110 O'CONNOR

REDEVELOPMENT PROJECT MIXED-USE BUILDING

SITE PLAN APPLICATION

OCTOBER 2025

1
A-201
ÉLÉVATION SUD
1 : 150

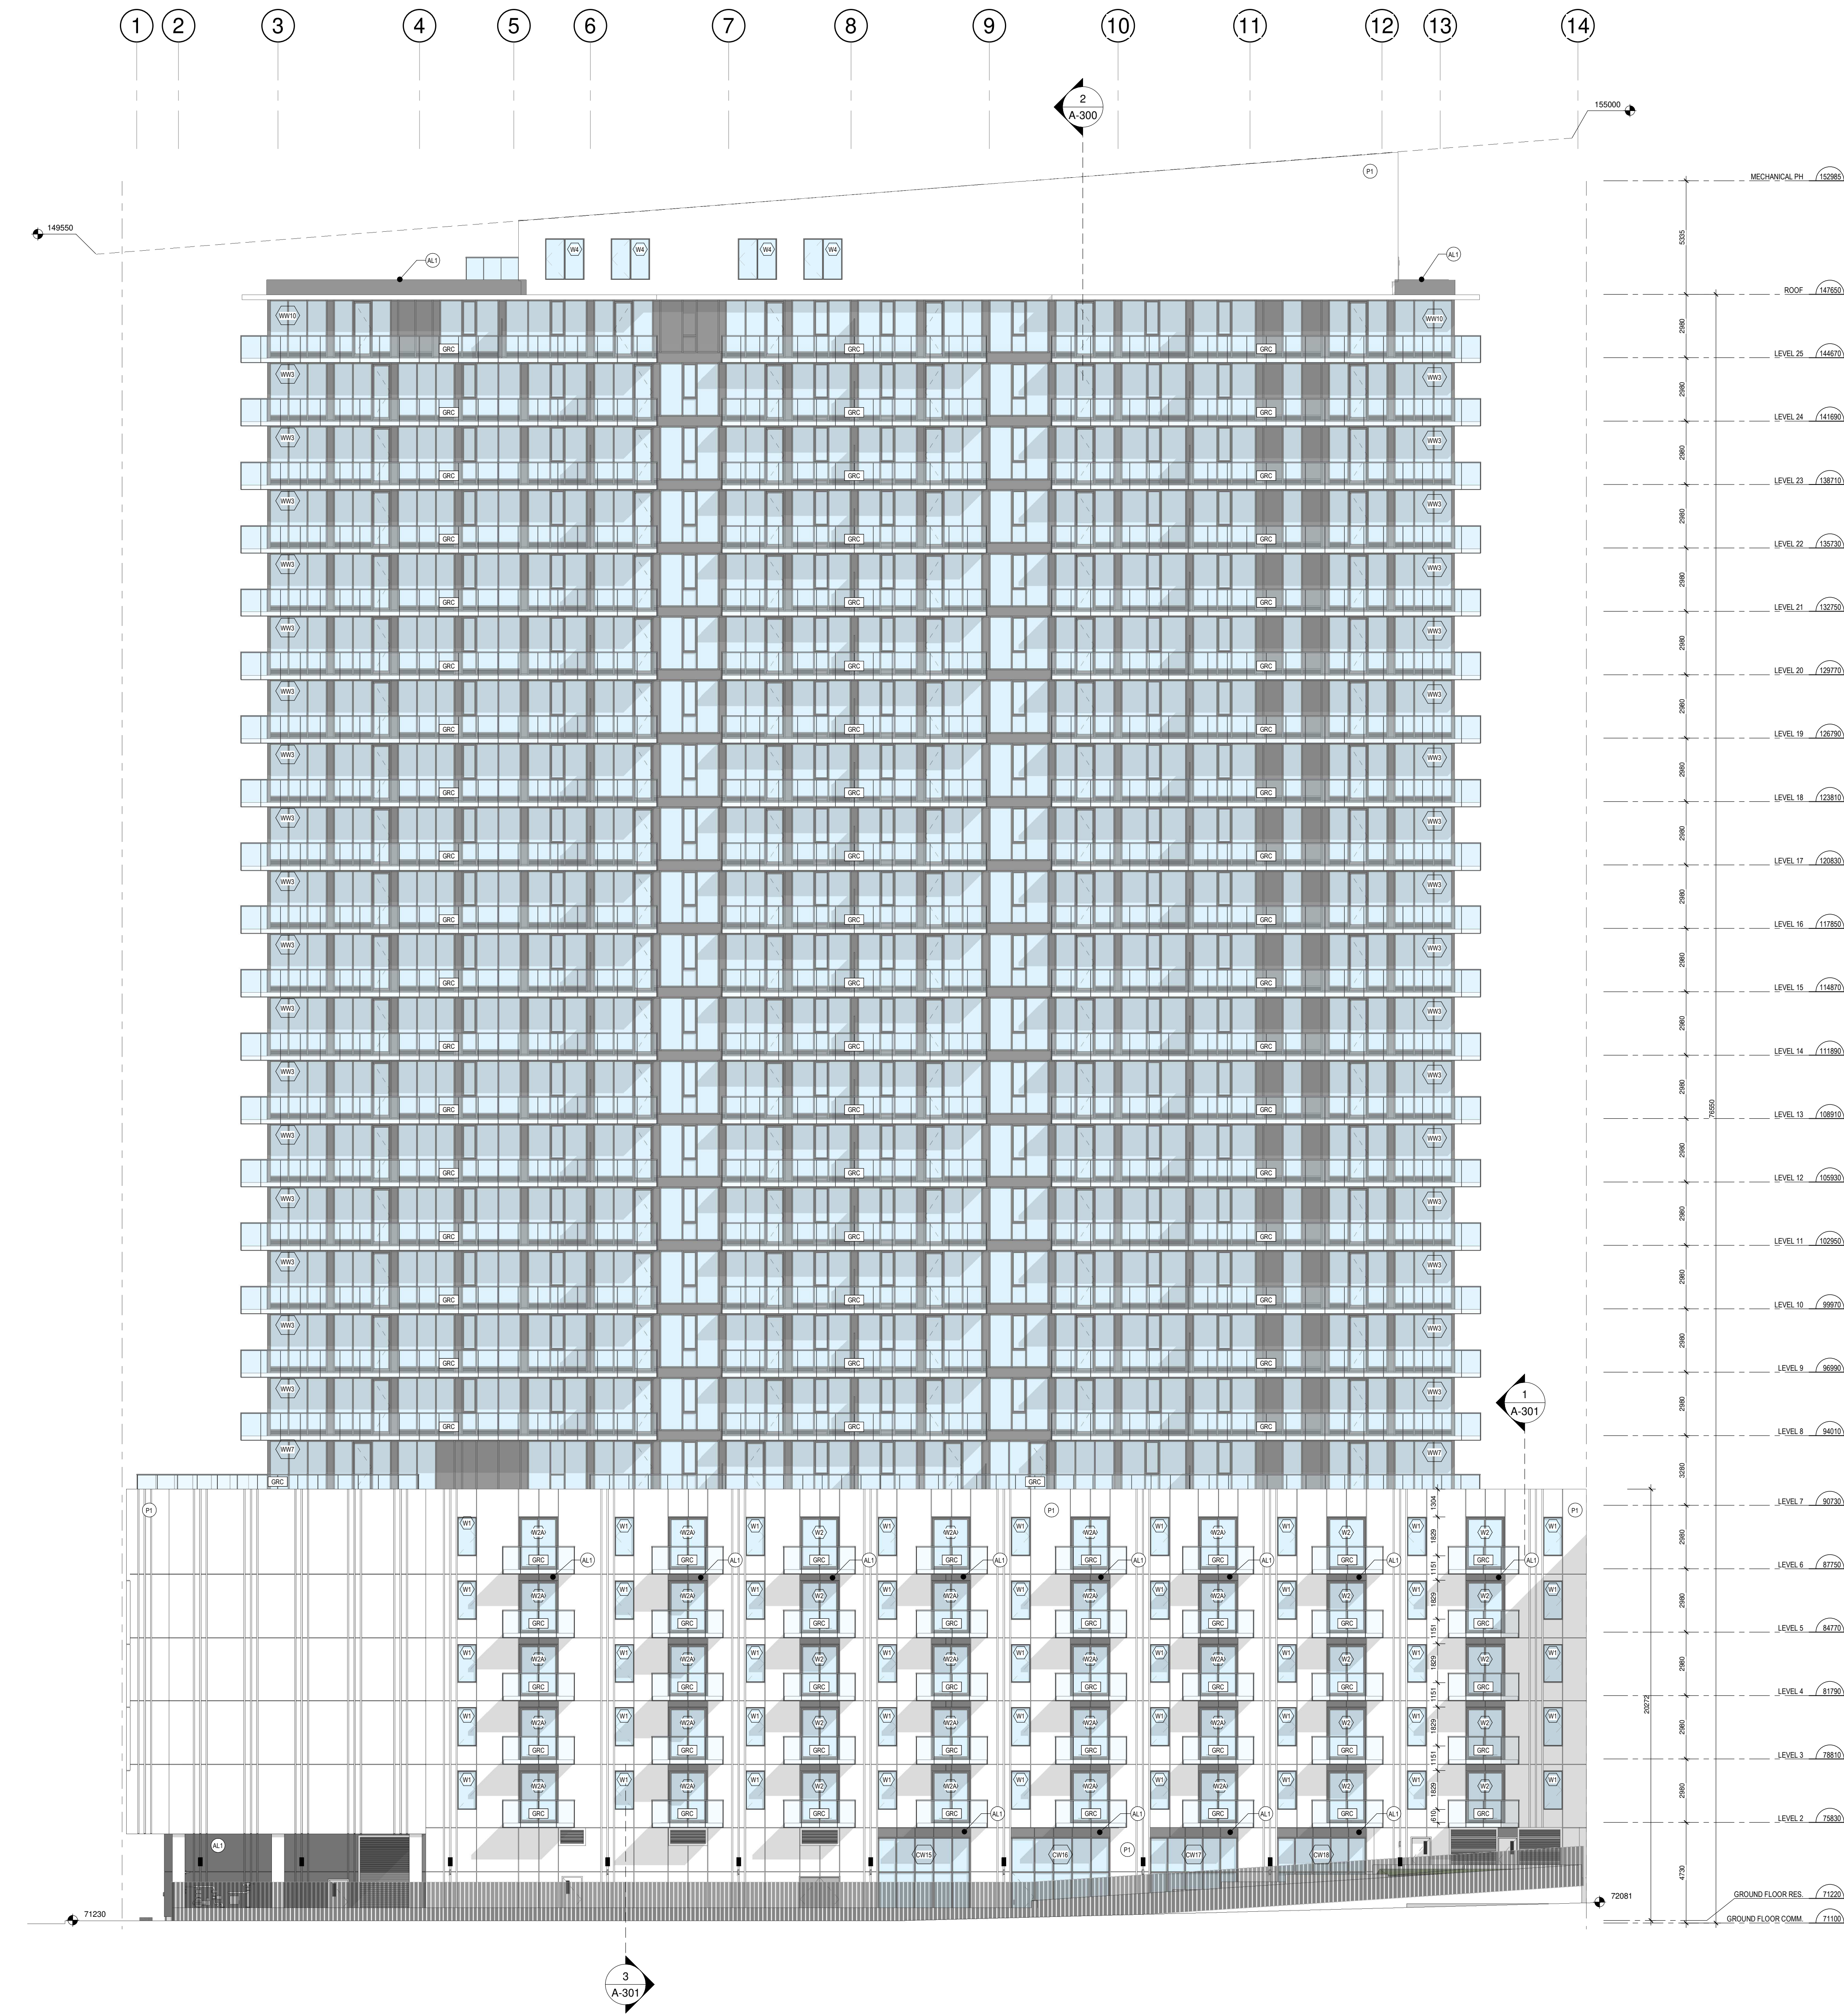
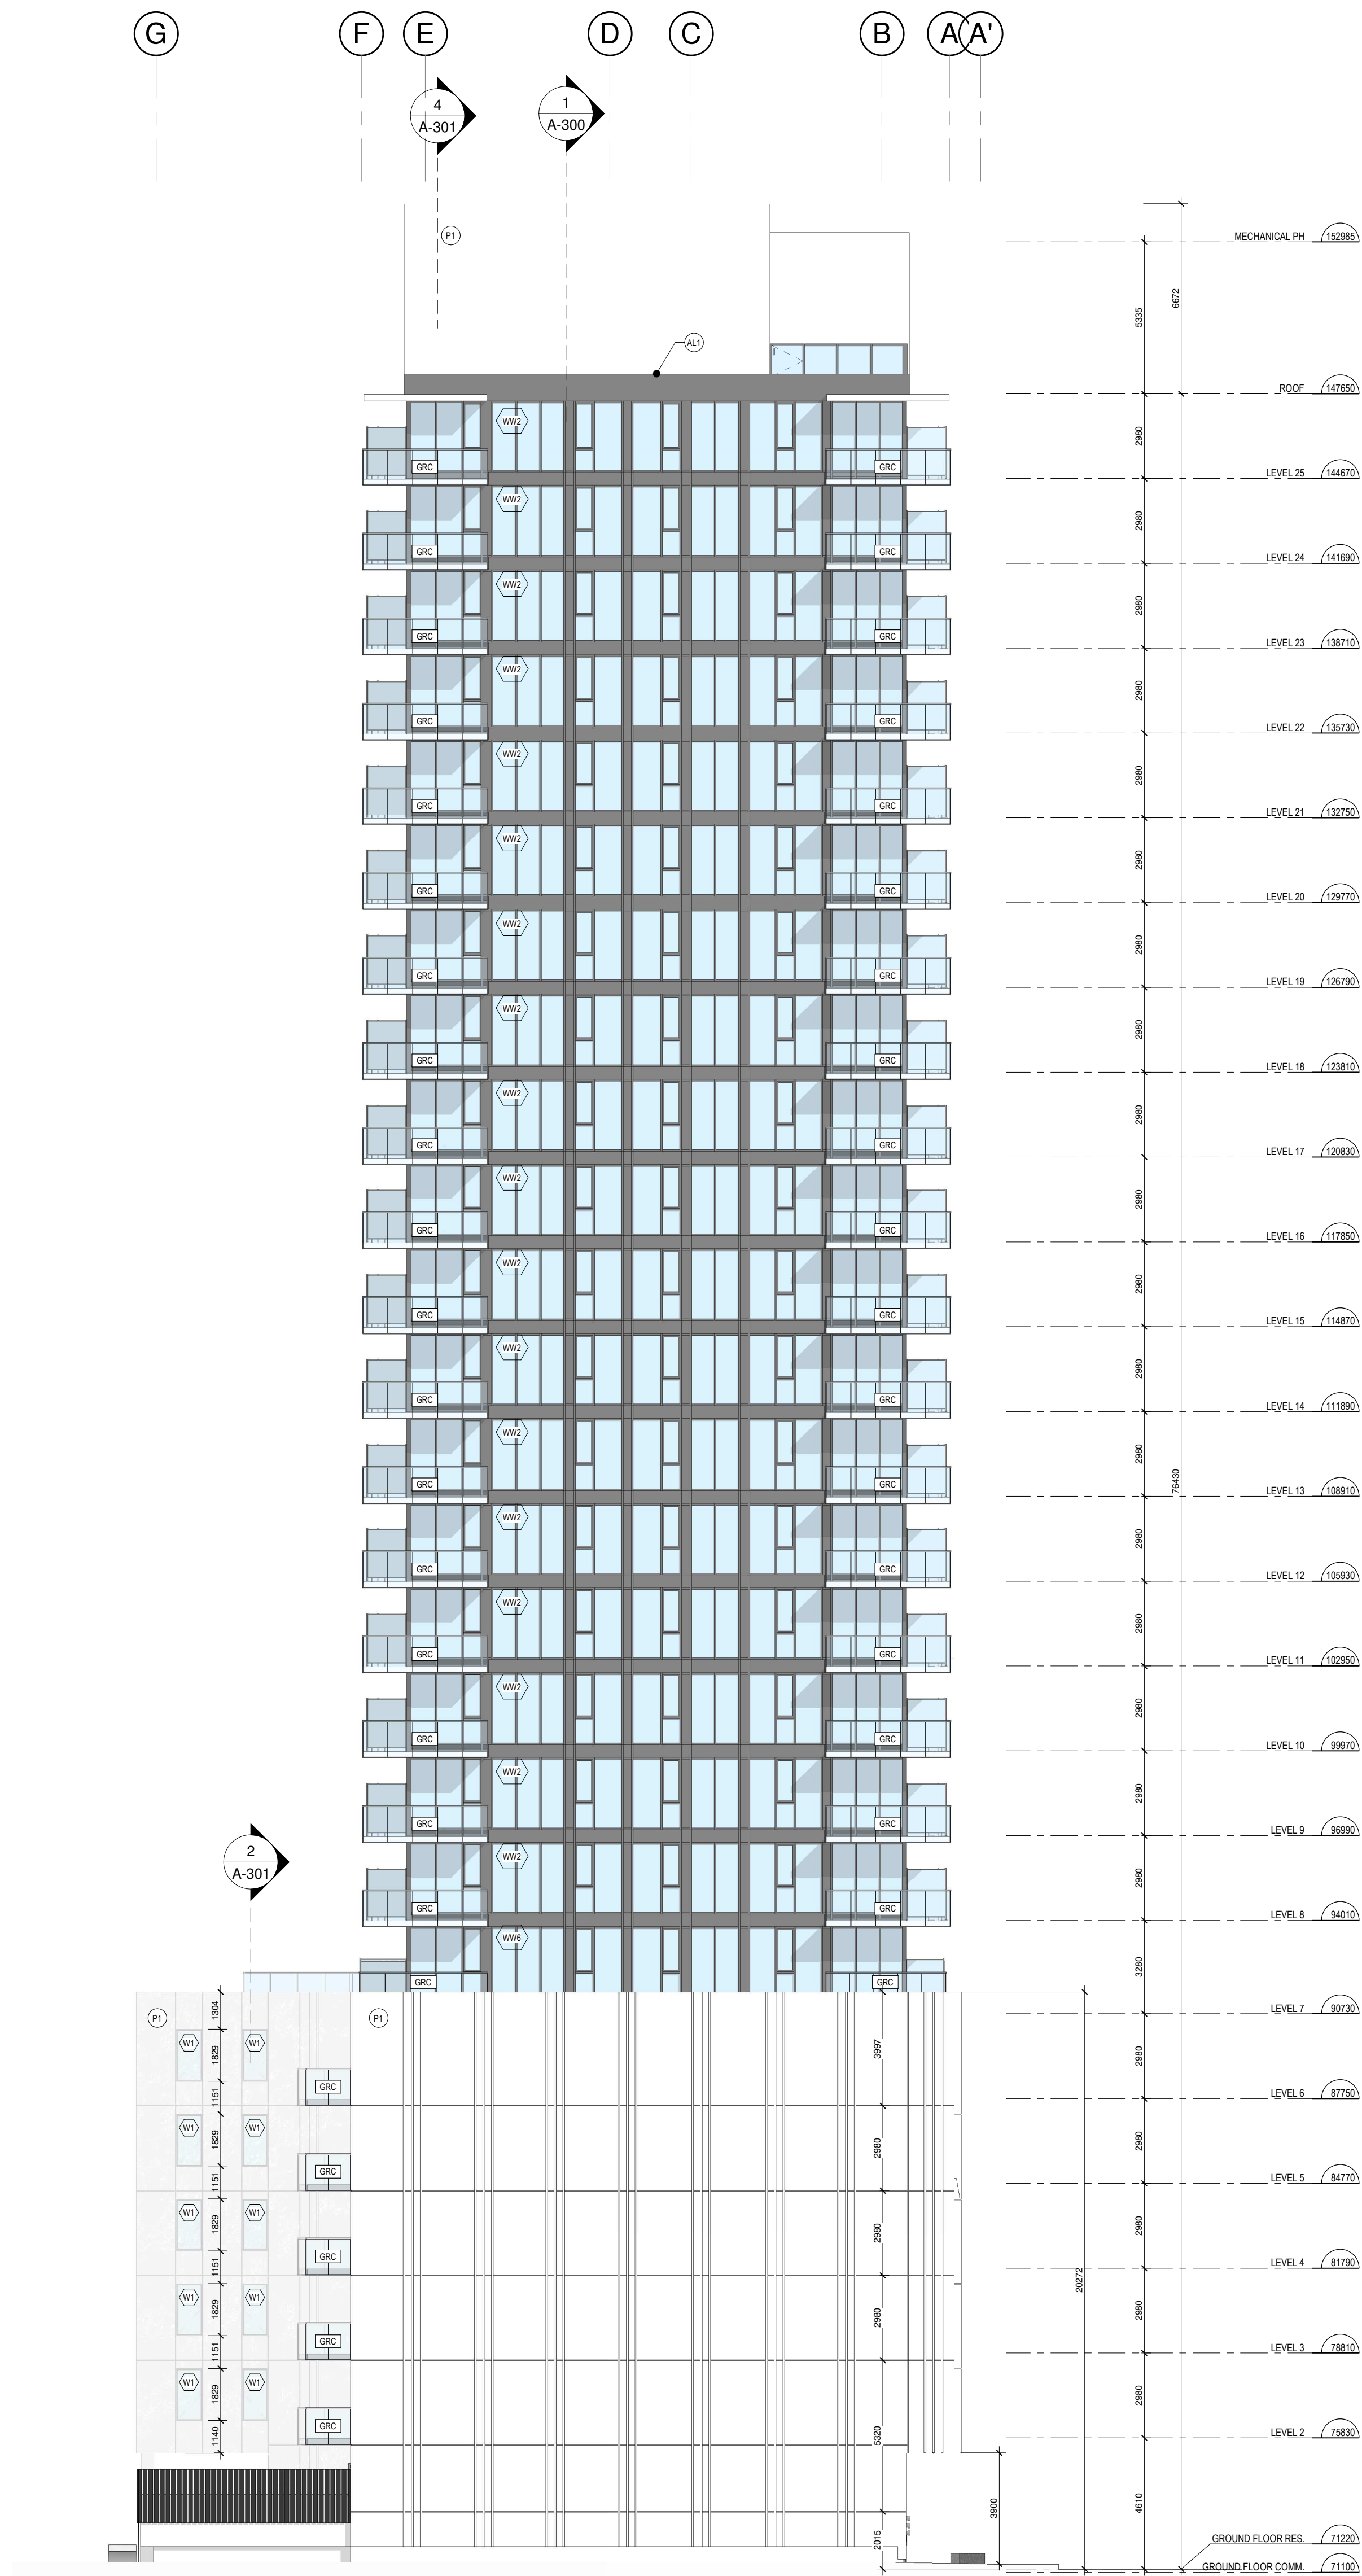
Reduce the height of the podium. The height and the articulation of the podium should take into consideration the width of the public streets, which are approximately 20m, and the heritage building at 124 O'Connor. A 6-storey podium would be more appropriate with respect to street proportion and relationship with the heritage building next door.

The facade of the podium should be responsive to the context, particularly to the heritage building at 124 O'Connor.

The podium height has been reduced to six (6) storeys.

Homage is paid to 124 O'Connor with the re-interpretation of the three recessed linear elements on its facade.
